Our Ref: EN020028

Date: 18 November 2024

Application by Morgan Offshore Wind Limited and Morecambe Offshore Windfarm Limited for an Order Granting Development Consent for the Morgan and Morecambe Offshore Wind Farms Transmission Assets project

Advice following issue of decision to accept the application for examination

Figure 1.7: Outline management of PRoW within the Onshore Order Limits (Sheet 5)

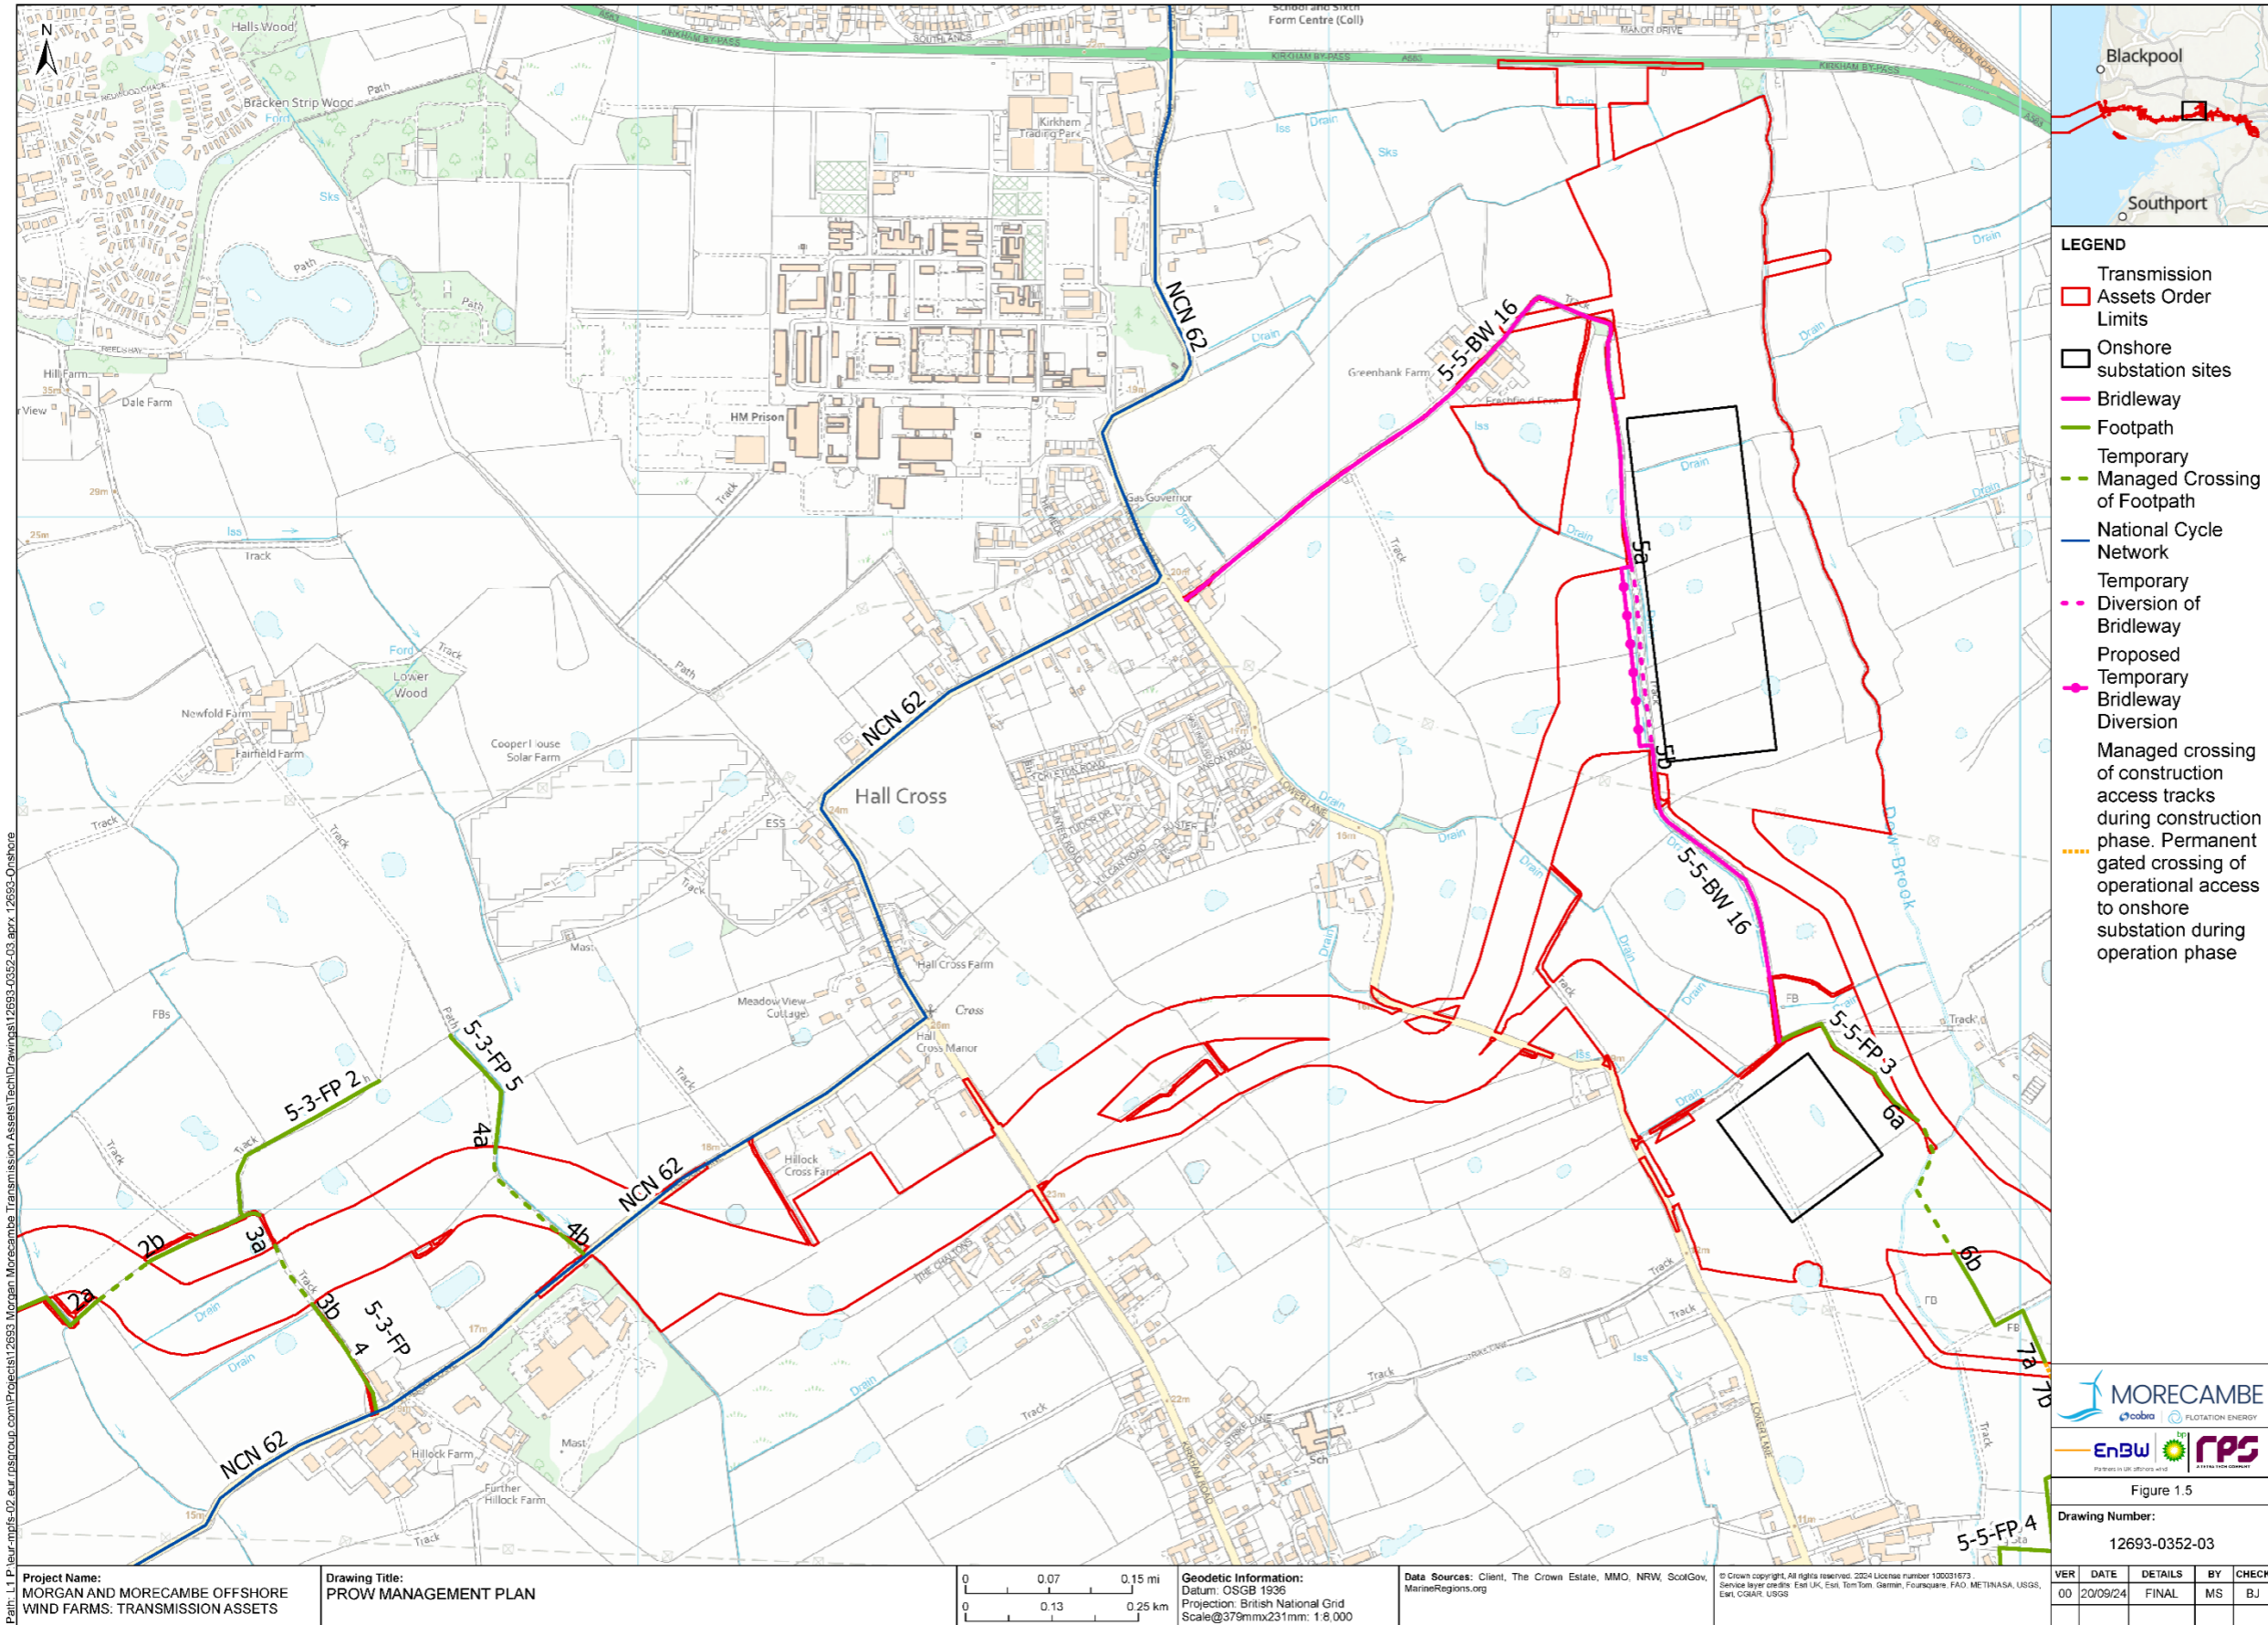
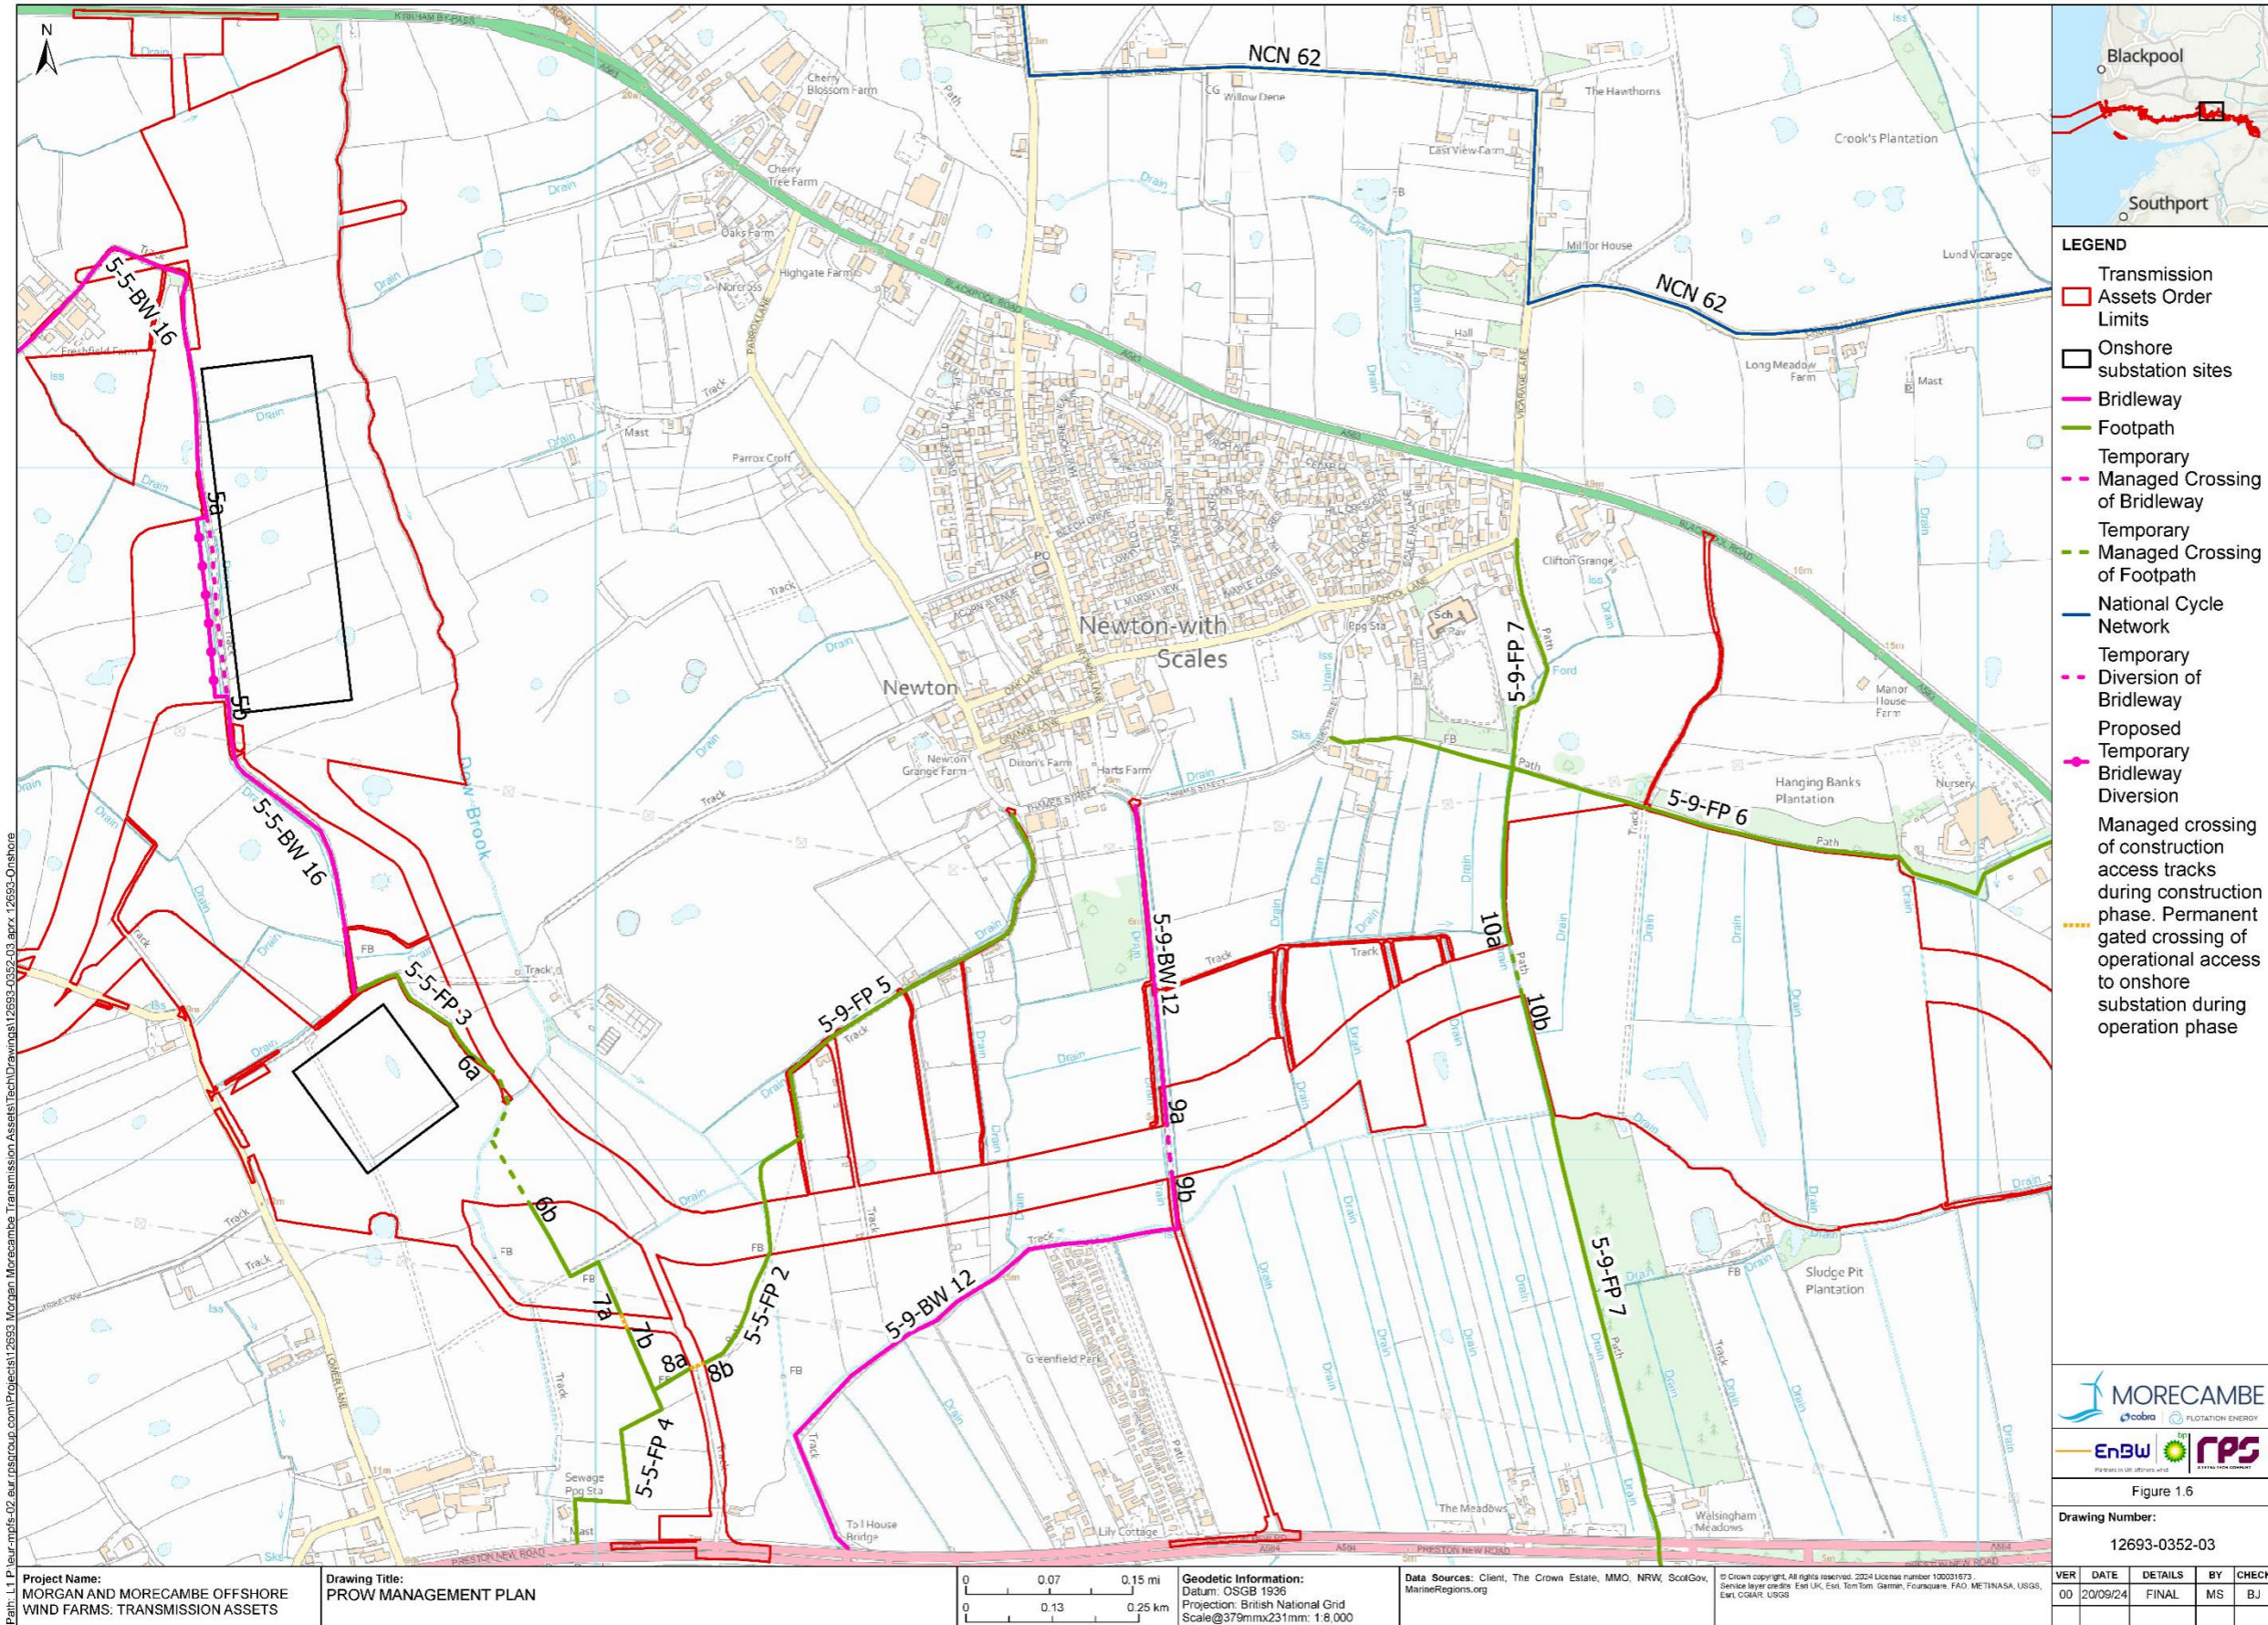
These plans should be reviewed for accuracy and readability, including how the keys/ledgers relate to the information portrayed on the plans.
